10 December 2020

### **SSI-10040 - PROJECT ENERGY CONNECT (NSW – WESTERN SECTION)**

I refer to your correspondence regarding the subject Application which was referred to Transport for NSW (TfNSW) for assessment and comment.

Figure 6-8

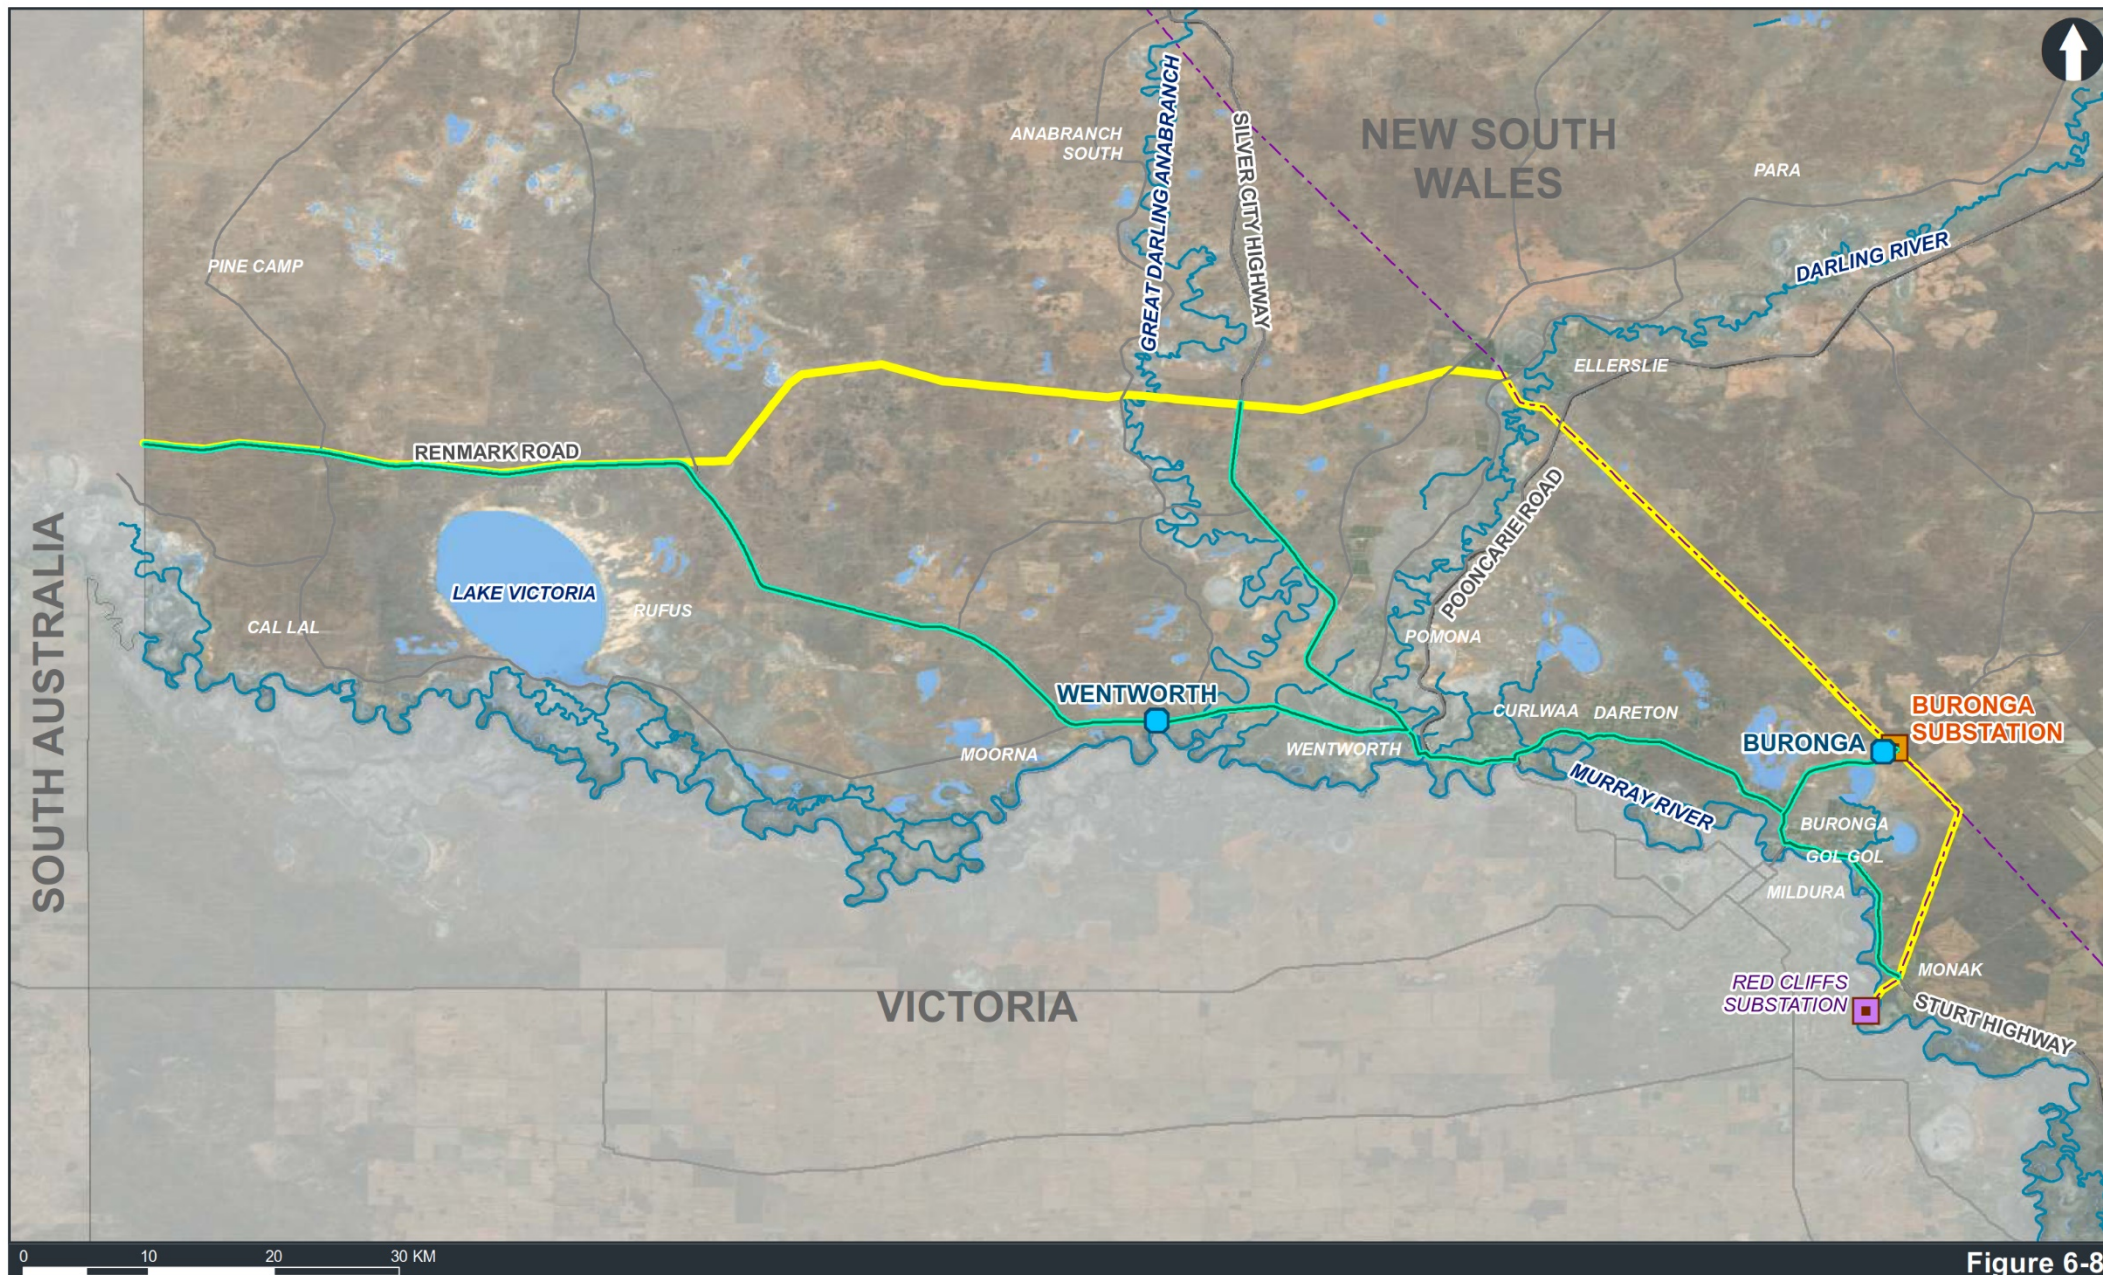
Section 18.4.5 refers to the potential haulage routes however the submitted documentation provides limited information in relation to the number and size of the oversize and overmass (OSOM) vehicles required to deliver components, including substations. The documentation lists four potential haulage routes depending on the port of origin of the components, including from Melbourne and Adelaide. The information provided does not currently address details of potential pinch points and specific mitigation measures required. More detailed information is required to allow for an informed assessment of the potential impacts on the road network.

The logistics associated with the transportation of materials for the development needs to be addressed. When the preferred haulage route is selected a full and independent risk analysis and inspection of the route may be required to be prepared and supplied for comment. Further analysis and reporting to assess possible damage to, and repair of the route will be required on a regular basis.

Figure 2.2 Proposed Wentworth construction compound and accommodation camp site location

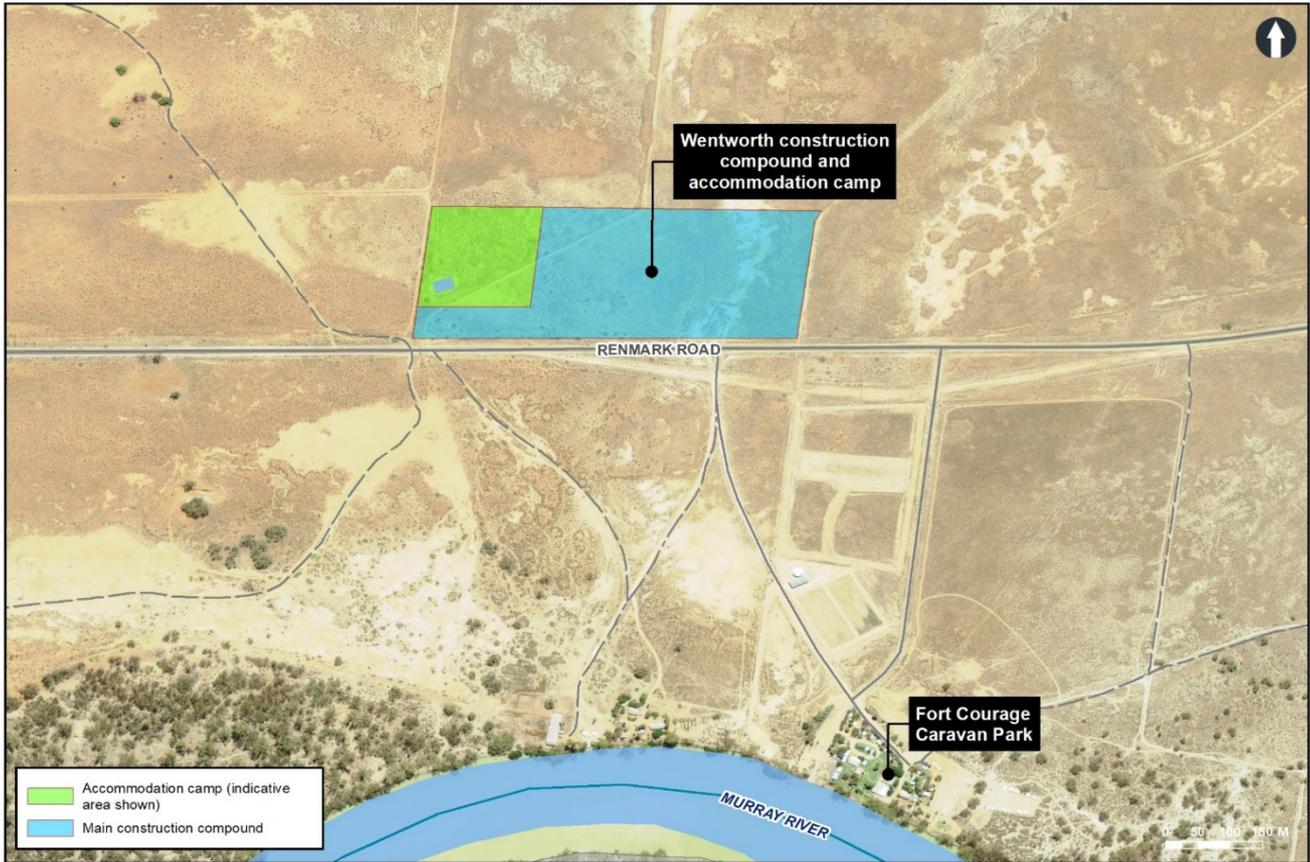
TfNSW has reviewed the proposed site for the work camp to be located with frontage and access to the Silver City Highway north of Wentworth and has concerns regarding the location of the site remote from Wentworth within a high speed environment. It is understood that the information provided in the EIS does not reflect the latest intentions for the location of the workers camp and compound sites for this project. It is understood that there are now 2 sites considered for this purpose. One compound located near to the existing substation located to the north of Buronga and will be accessed from Arumpo Road (MR431). The other compound site located near Fort Courage Caravan Park and will be accessed via Renmark Road (MR68).
